Department of Transportation

July 2, 2024

RE: Self-Storage - Platte Frontage Rd. (PPR2418)

PLATTE SELF STORAGE STREET IMPROVEMENT PLAN OVERVIEW SHEET AUGUST 2024

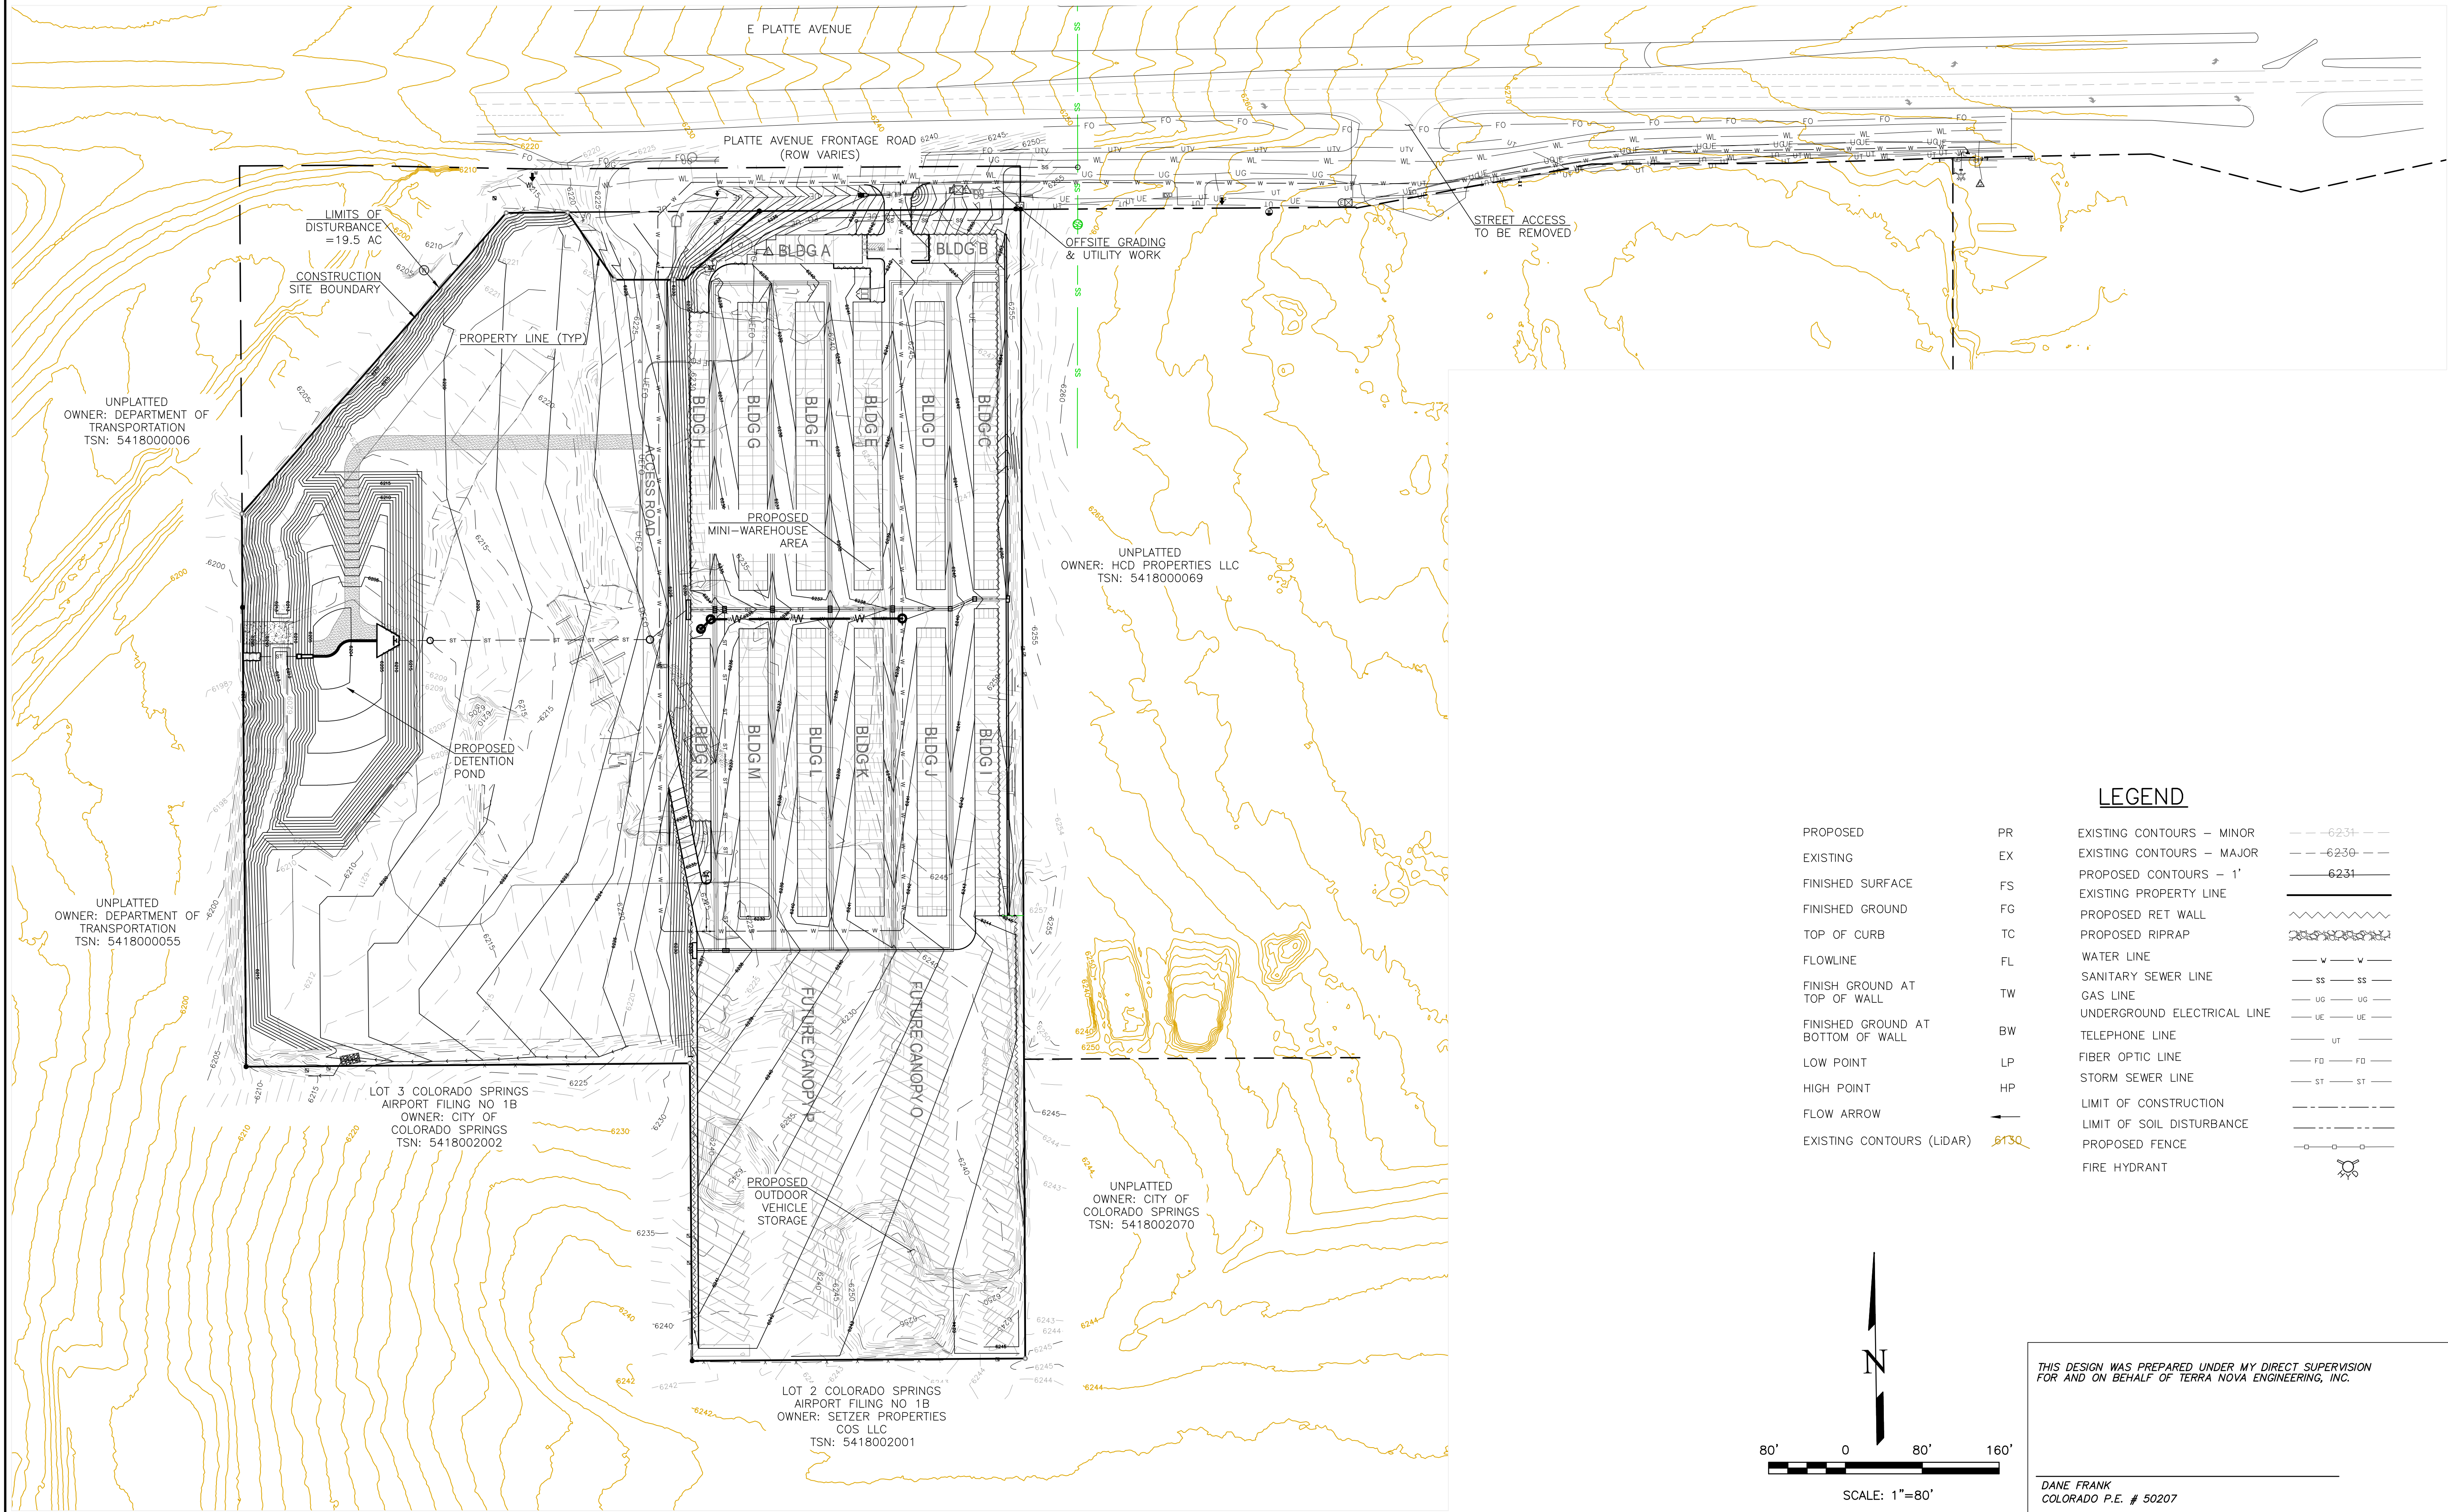
- TIS is approved and requires the removal of the existing RIRO mid-block access to State Highway 024G and turned into a right turn lane collector to the intersection of 24G and Motel Rd. The removal of the existing access shall include, but not be limited to, the return of highway right-of-way slopes, ditches, and fences to match existing adjacent conditions, including removal of asphalt aprons and culverts. Any asphalt removed from the highway shall result in a smooth finished edge [thus the only access to the south frontage road (Motel Road)] will be to the east at the intersection with Hathaway Drive/Motel Road (Frontage Road).

- The existing asphalt turn-lane apron shall be sawcut and removed to form a straight line west-to-east leaving a 4-foot shoulder for the creation of the extended right-turn lane to the south to access Motel Road.

- The existing roadway solid striping shall be removed to include the solid median triangle and lane dash lines to be replaced with a solid white shoulder line and 8-inch-wide dotted lines for the extended right-turn lane per CDOT Standards.

- Additional pavement markings including right-turn arrows are required of this construction per CDOT Standards.
- Existing signage shall be removed and become property of the Permittee to dispose of ((1) right-turn lane must turn right near the asphalt removal section and (1) stop sign)). Additional delineator posts are required of this permit and the signage for the beginning of the right-turn lane.

- Fill slopes and cut slopes shall be constructed to current Department minimum standards.
- The median shall be regarded to match the adjacent, surrounding areas. Drainage shall be considered while regrading not to allow for ponding of storm water drainage flows.
- The existing subgrade or base course material below the asphalt mat shall be removed and become property of the Permittee to be disposed of.
- Seeding and mulching is required of this permit to re-establish the roadway median vegetation.
